Markup Summary

SPECIAL USE DRAWING

PCD File No.: AL193

PLOT PLAN / SPECIAL USE DRAWING

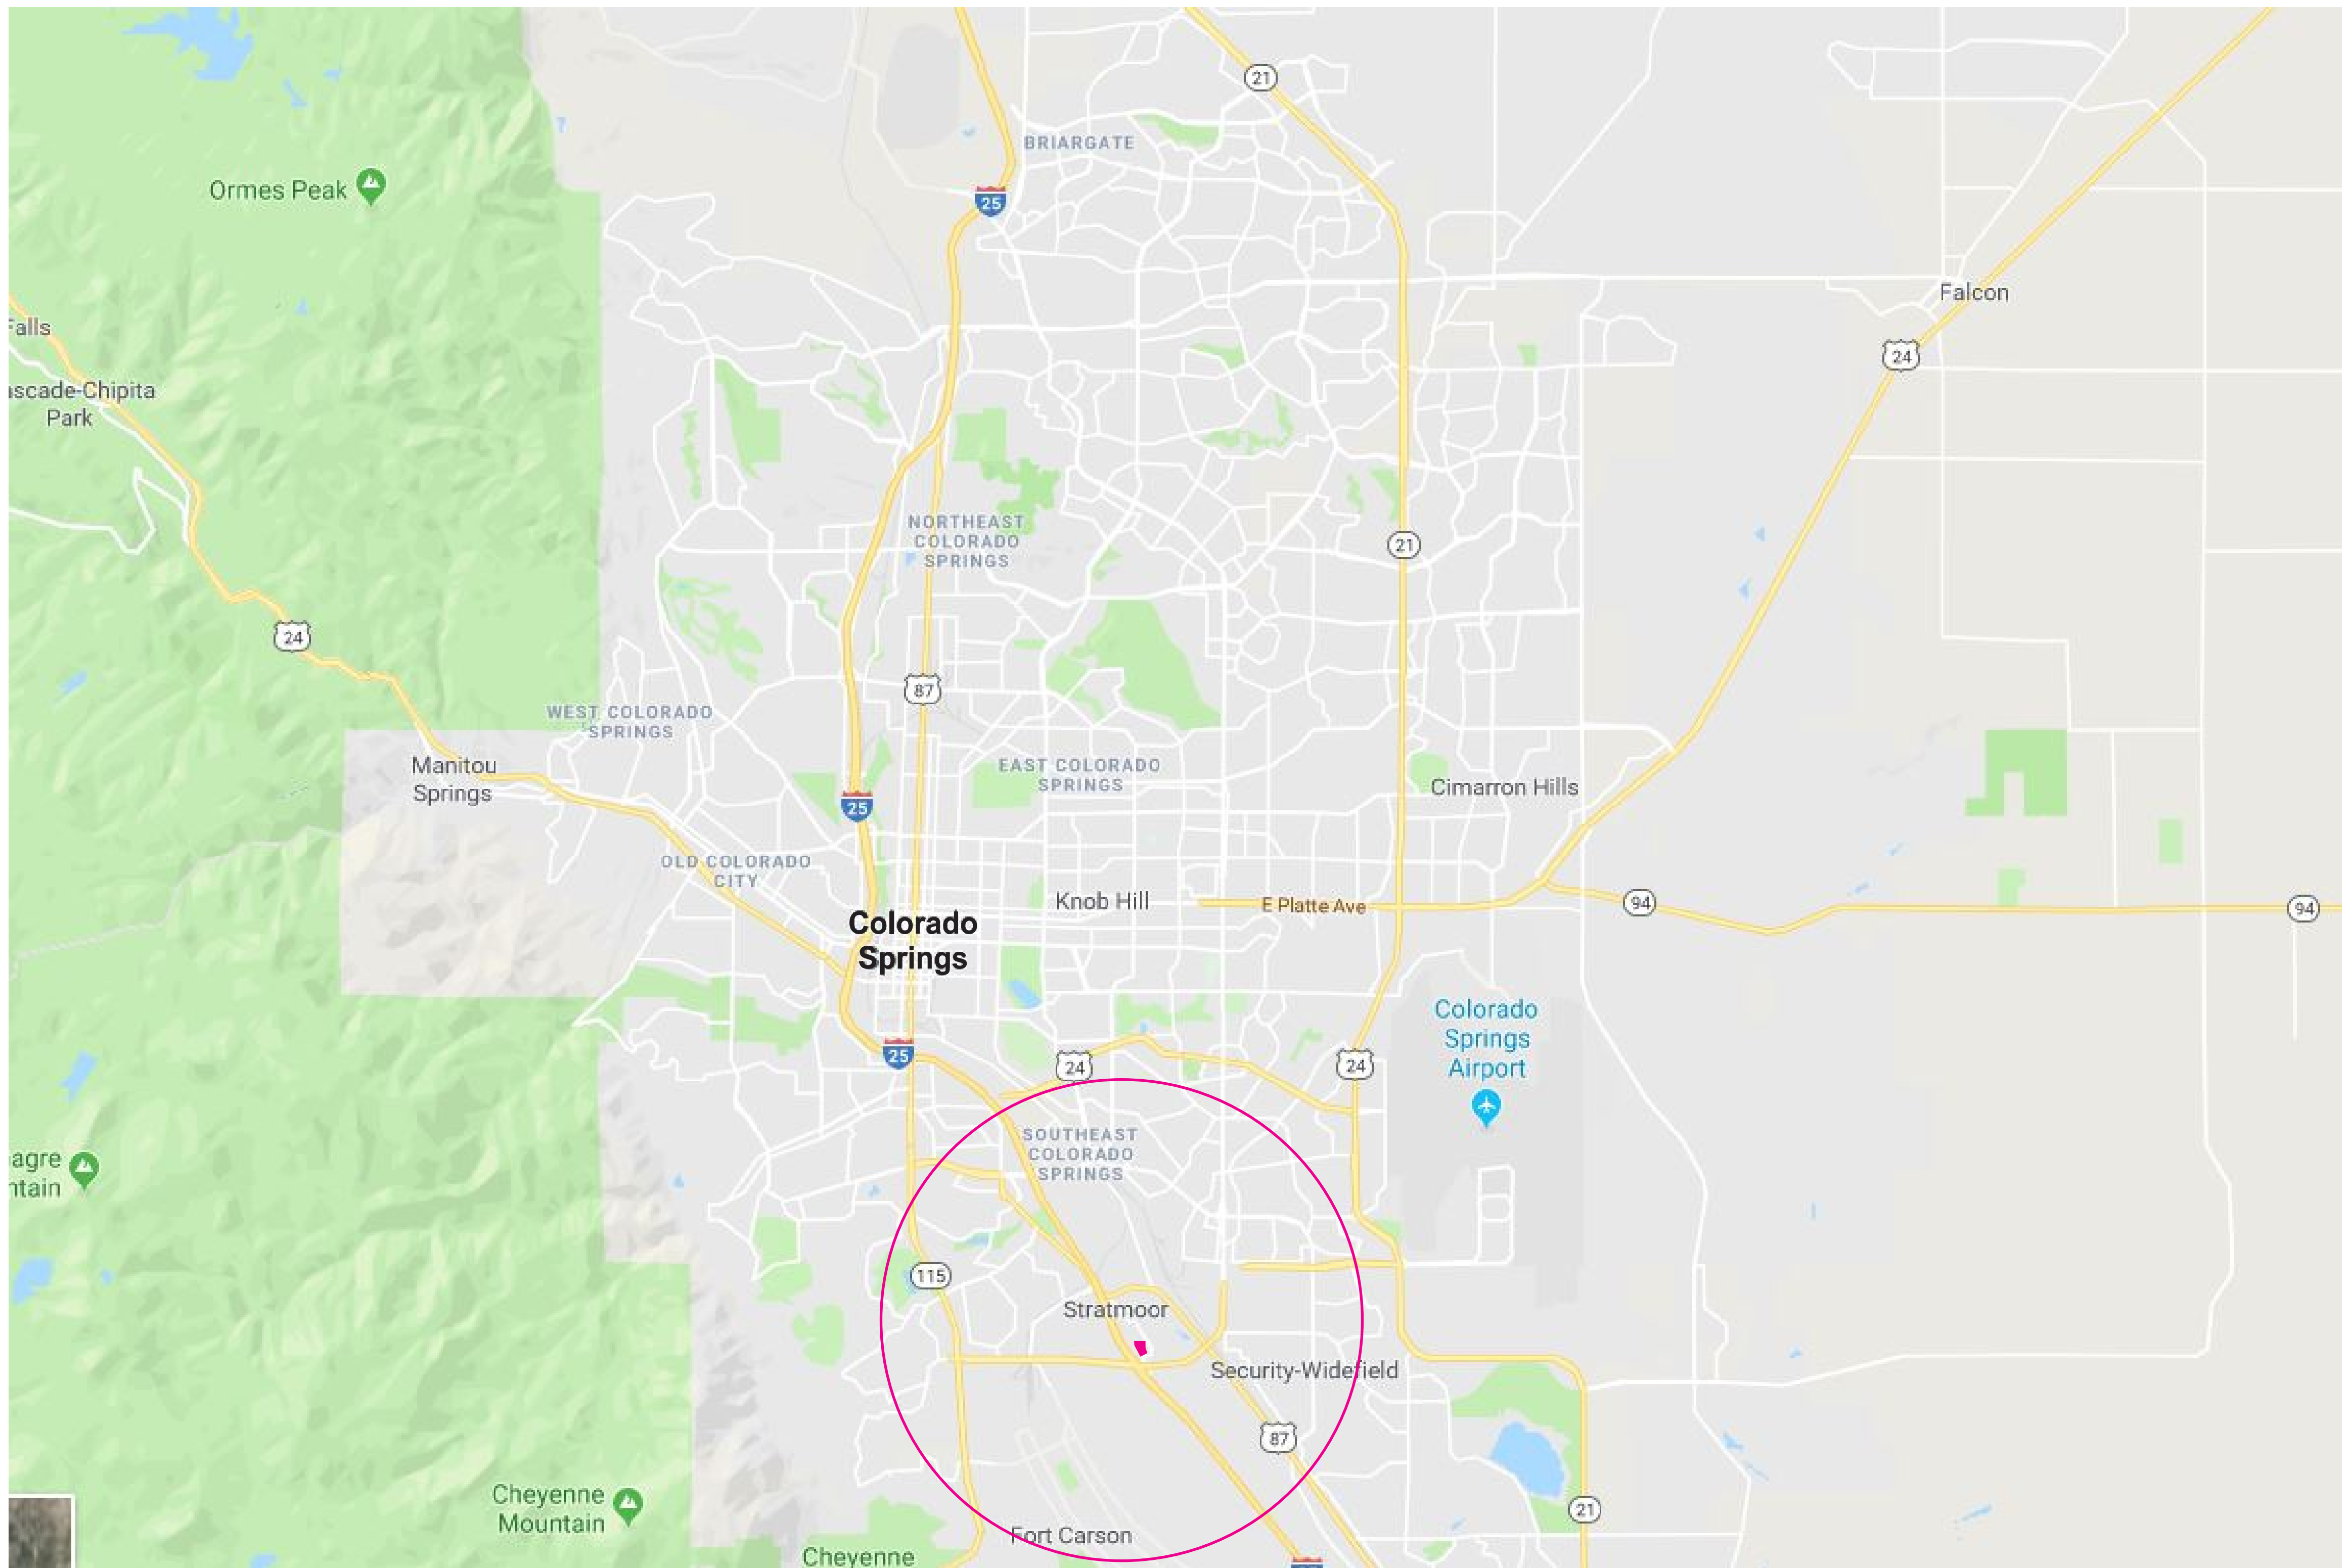
The storage areas need to be more specific. Only half of the front yard setback is allowed to have storage areas which would be the easterly property boundaries. All parking shall be shown, as well as areas that are to be used as specific storage.

Show all easements from plats.

These lot lines shall remain cleared.

Potential Sight Triangles. Fences in these areas shall not exceed 30 inches.

This landscaping would require a work in the right-of-way permit and will the landscaping requirements of Chapter 6 of the Land Development Code will be reviewed in the Site Development Plan Process.
